**Marine
Management
Organisation**

MMO Reference: DCO/2022/00007
Planning Inspectorate Reference: EN010125
Identification Number: 20050160

Planning Act 2008, RWE Renewables UK Dogger Bank South (West) Ltd and RWE Renewables UK Dogger Bank South (East) Ltd Proposed Dogger Bank South Offshore Wind Farms Order

Deadline 2 Submission

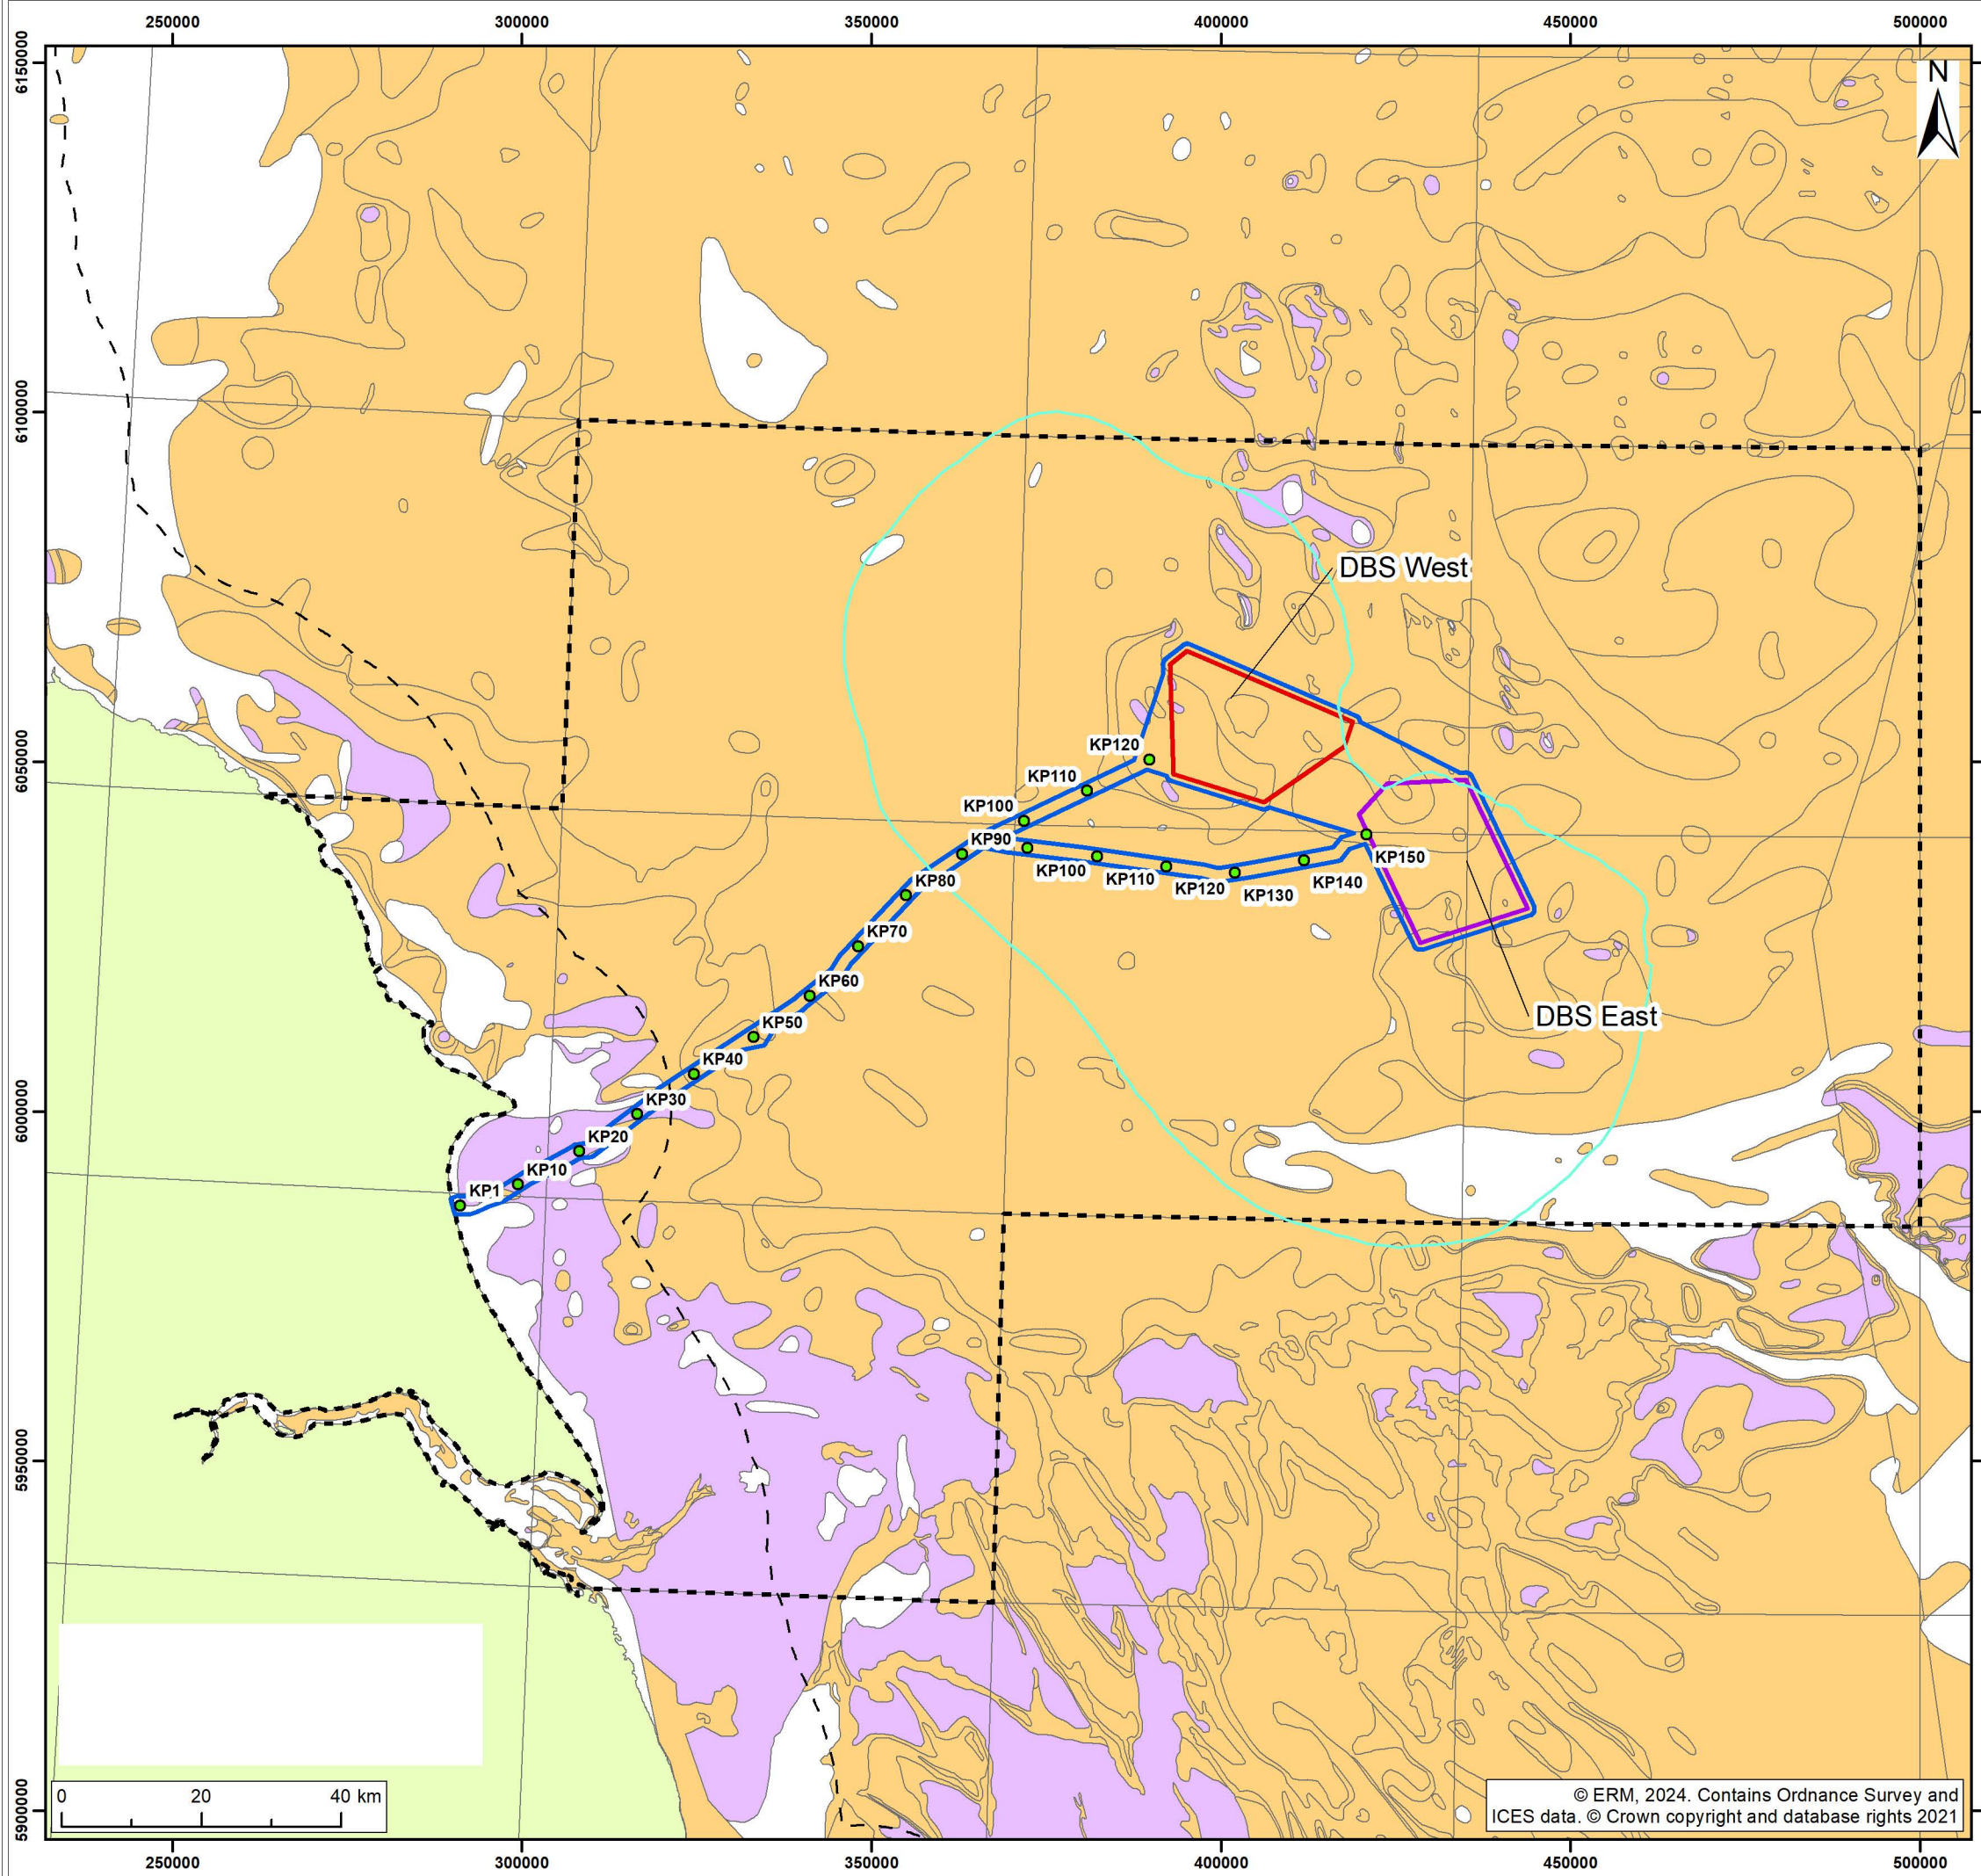
2.2.3 The updated sandeel heat map (Figure 3.1) indicates that the majority of the Humber region, including the DBS export cable corridor (ECC) and the array areas represent suitable supporting habitat for sandeel. OneBenthic sandeel presence data indicates that sandeel have been recorded within the proposed array area. The underwater noise (UWN) contours for mortality and potential mortal injury (219 decibel (dB) cumulative sound exposure level (SELcum), recoverable injury (216 dB SELcum), and temporary threshold shift (TTS (186 dB SELcum), as per the pile driving threshold guidelines described by Popper *et al.* (2014), have been included on Figure 3.1 for reference which is helpful. Sandeel do not possess a swim bladder which is involved in hearing and so the impact ranges for the effects of mortality and recoverable injury are highly localised. The impact range for the effects of TTS extends over a much larger area that is comprised of high and medium-high confidence sandeel habitat.

Figure: 2.1	Drawing No:	
Co-ordinate system: WGS 1984 UTM Zone 30N	Page Size: A3	Scale: 1:850,000
Project:  Dogger Bank South Offshore Wind Farms	Report:

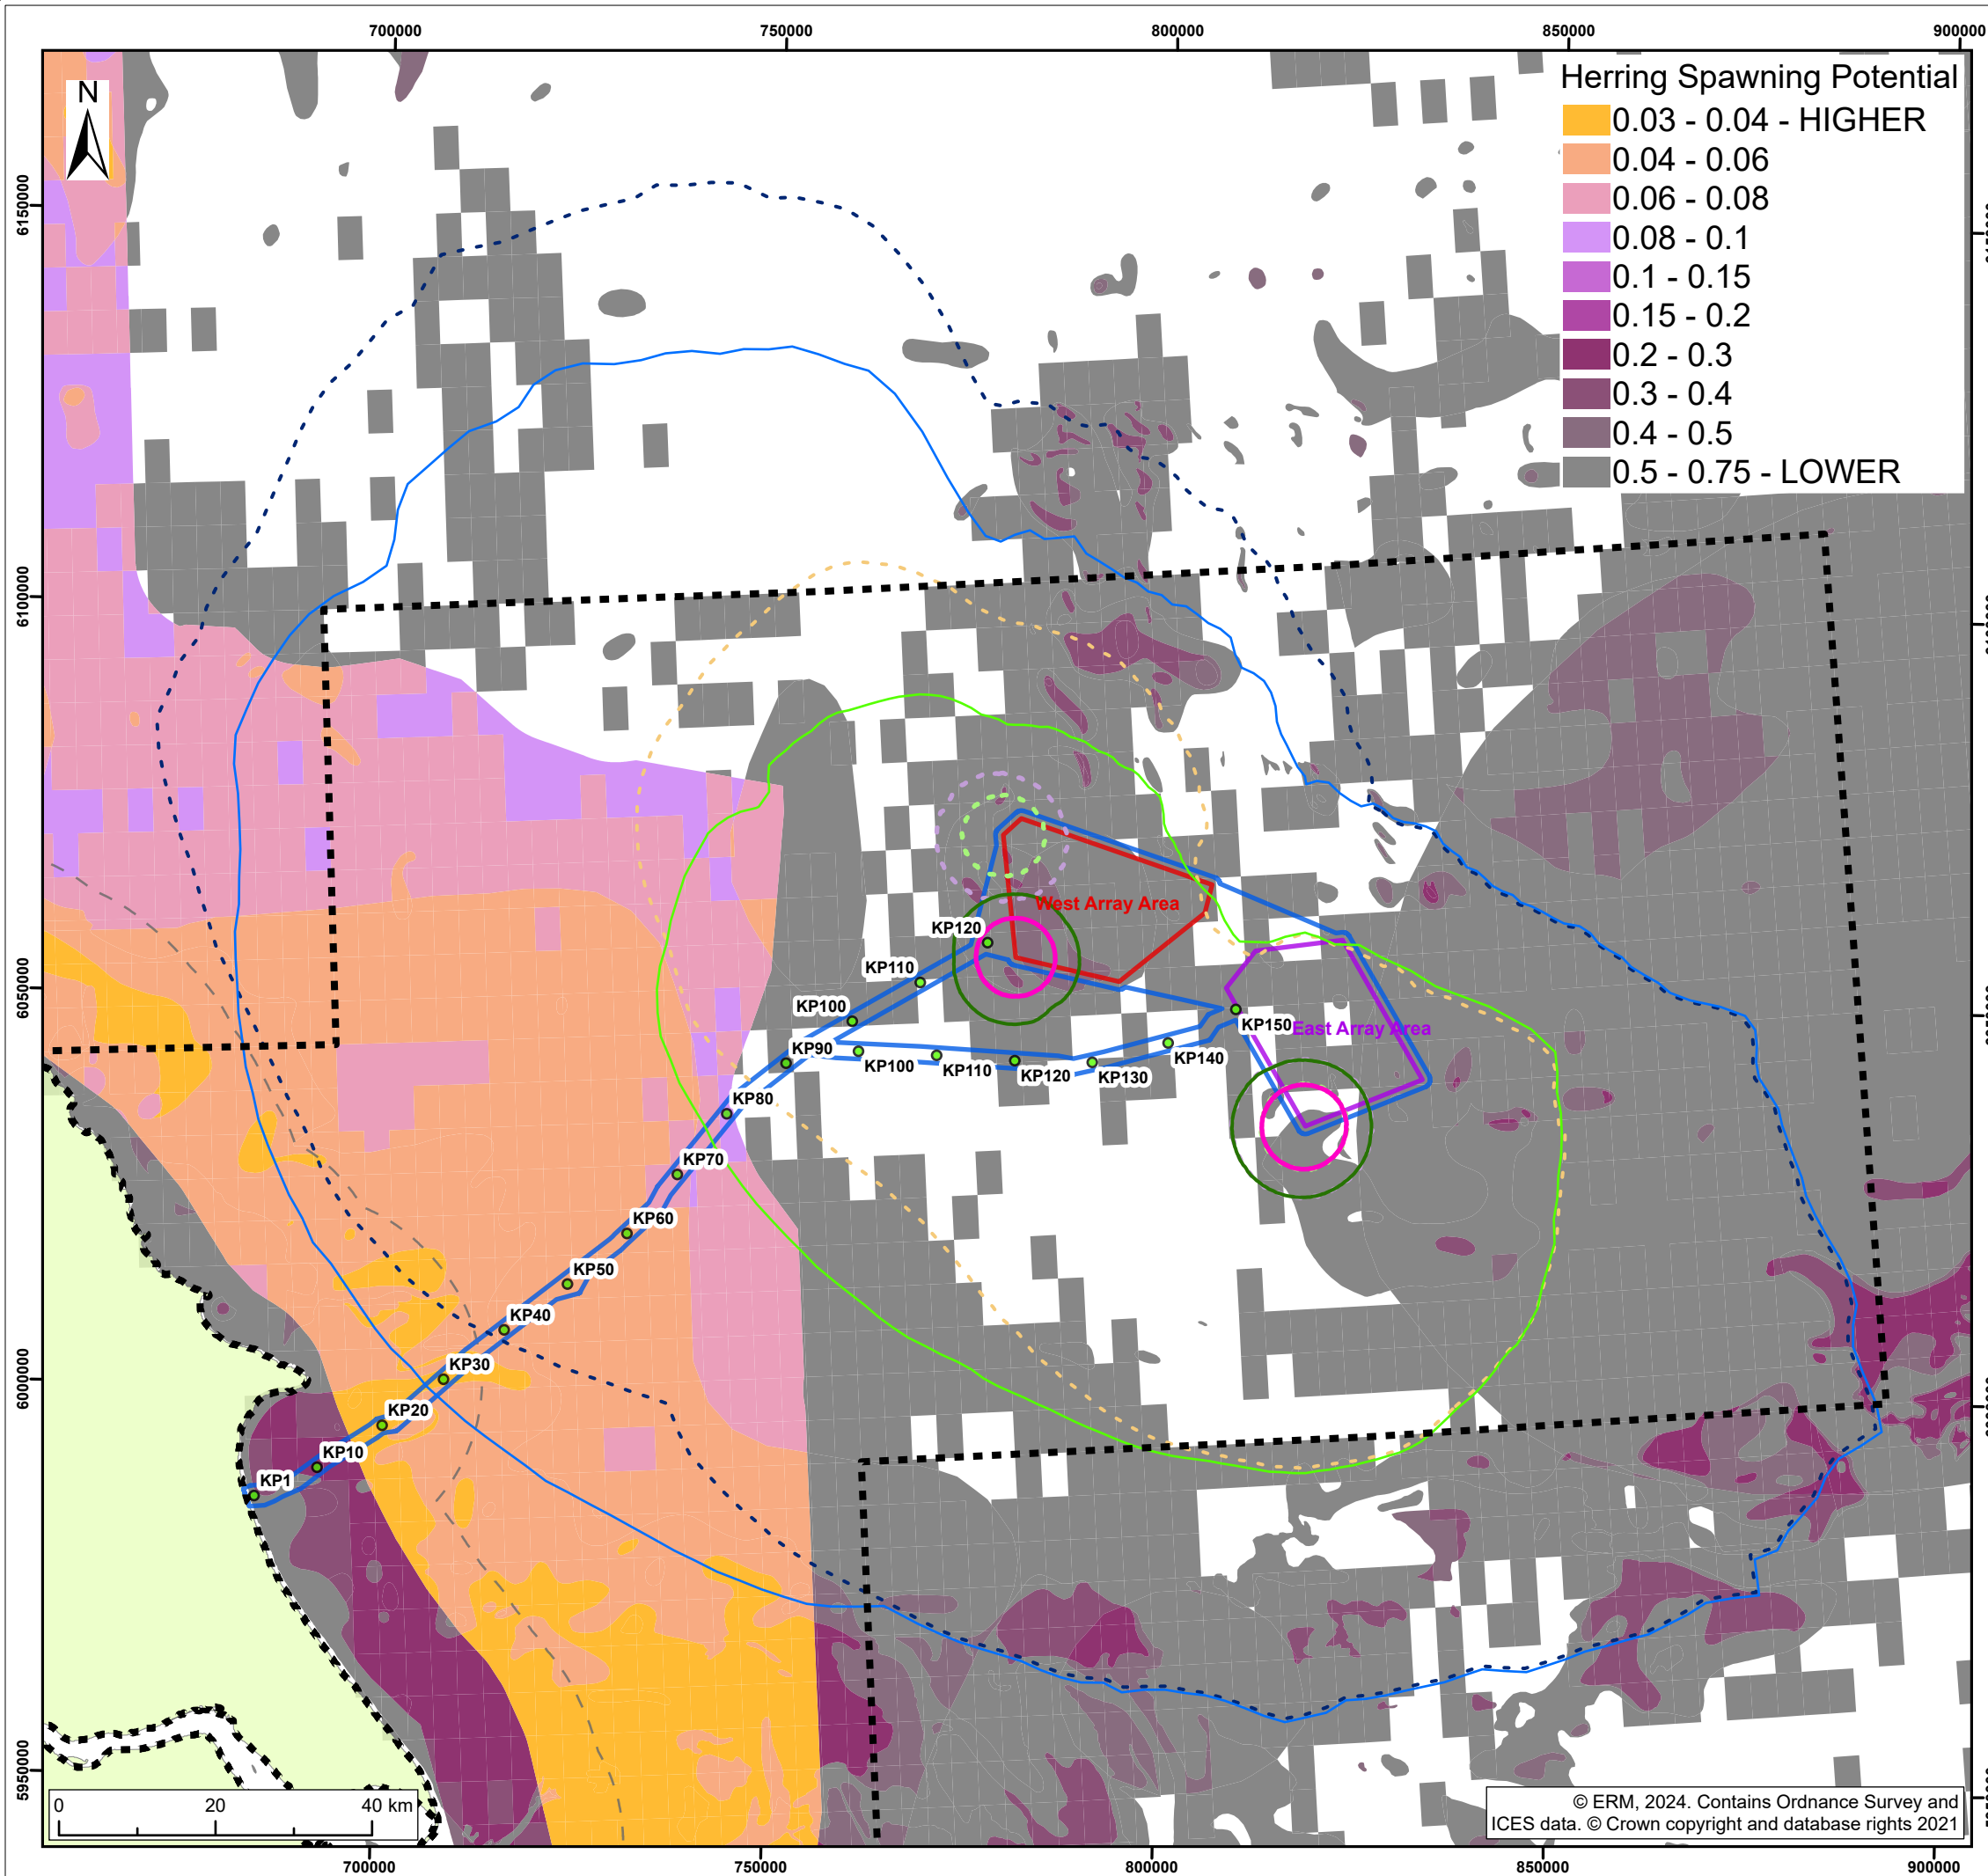
behavioural effects (135 dB SELss) in herring, have been included on Figure 2.1 which is helpful in understanding the range of impact from UWN based on the Applicant's new piling profile (which does not include the Electrical Switching Platform (ESP) within the ECC). It is assumed that the UWN contours provided in Figure 2.1 represent unmitigated monopiling based on the Project's worst-case piling scenario.
